**Colorado Springs, CO  
Planning and Development**

**Final Report - Corrections Required**  
**Application No. ANEX-23-0009**

**Description :** A request by Norris Ranch Joint Venture, LLC, for annexation of 1.224 acres into the City of Colorado Springs. The annexation is a part of the overall Karman Line Land Use Plan, which is being submitted concurrently. The Land Use Plan proposes a maximum of 6,500 dwelling units, approximately 45 acres of light industrial, 105 acres of commercial/retail, 100 acres of mixed-use development, and 570 acres of park/open space.

ANNEXATION PLAT KARMAN LINE NO. 1

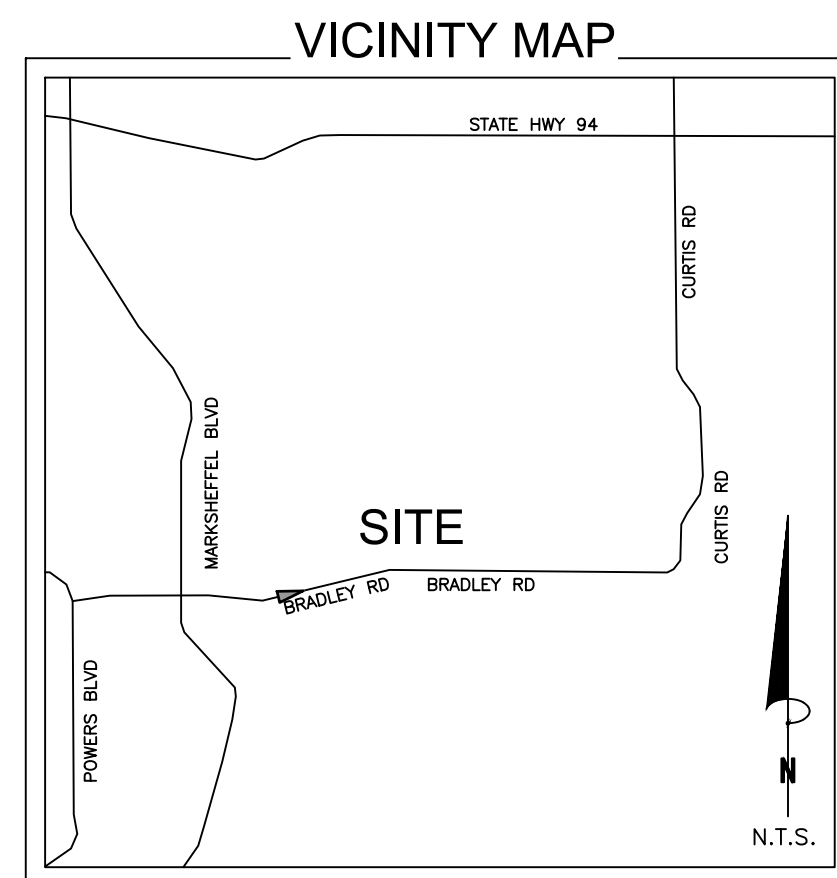
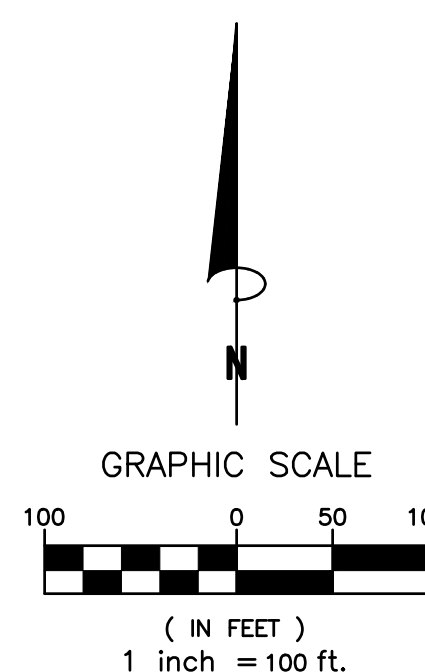
-	1	Cory Sharp : Planning	
-	1	Cory Sharp : Planning	
3	1	Cory Sharp : Planning	Please complete the City File No. ANEX-23-0009
4	1	Cory Sharp : Planning	Please update the Recorder's name Steve Schleiker, Recorder
5	1	Cory Sharp : Planning	Please update the name Karman Line Addition No. 1
6	1	Cory Sharp : Planning	Please update the name accordingly
8	1	Cory Sharp : Planning	Please update the reception no. for Bradley Road 222103960
9	1	Cory Sharp : Planning	Please remove the El Paso County signature and notary
10	1	Cory Sharp : Planning	<p>Please update the ownership: Owner: The aforementioned, City of Colorado Springs, Colorado, a home rule city and Colorado Municipal Corporation, has executed this instrument this __ day of _____, 20__ A.D.</p> <p>----- John W. Suthers,</p>

21	1	Dan Sexton : Planning	Please revise the recordation information for this adjacent parcel. The reception number is: 222051558.
22	1	Dan Sexton : Planning	Please update the recordation information for this adjacent parcel. The El Paso County Assessor's website documents a number of reception numbers for the parcel.
23	1	Dan Sexton : Planning	Please add "*Unplatted*" labeling for all adjacent parcels that are not platted.
24	1	Dan Sexton : Planning	Please add "*Unplatted*" labeling for all adjacent parcels that are not platted.
25	1	Dan Sexton : Planning	The Owner is responsible for providing staff with a copy of the Letter of Inclusion from the Southeastern Water Conservatory District once received. This letter will need to be submitted to staff prior to scheduling for City Council hearing on this annexation.
26	1	Dan Sexton : Planning	The first draft Annexation Agreement will be supplied by staff to the owner after the 2nd review of the Land Use applications. This will establish further details for contributions beyond those identified in this letter.

27	1	Dan Sexton : Planning	Please provide a separate drawing for this annexation so compliance with the City's Water Ordinance can be confirmed.
28	1	Dan Sexton : Planning	The land associated with this annexation request appears to be part of the Rolling Hills Ranch Metro District. Prior to public hearing scheduling, the documentation must be provided to show that the roadway is not part of the district or has been deannexed.

Please update the name Karman Line Addition No. 1

Please remove El Paso County

Please update the reception no. for Bradley Road 222103960

Please update the ownership:  
Owner:  
The aforementioned, City of Colorado Springs, Colorado, a home rule city and Colorado Municipal Corporation, has executed this instrument this \_\_\_ day of \_\_\_\_, 20\_\_ A.D.

Please remove the El Paso County signature and notary

Please update the name accordingly

Please update the Recorder's name Steve Schleiker, Recorder
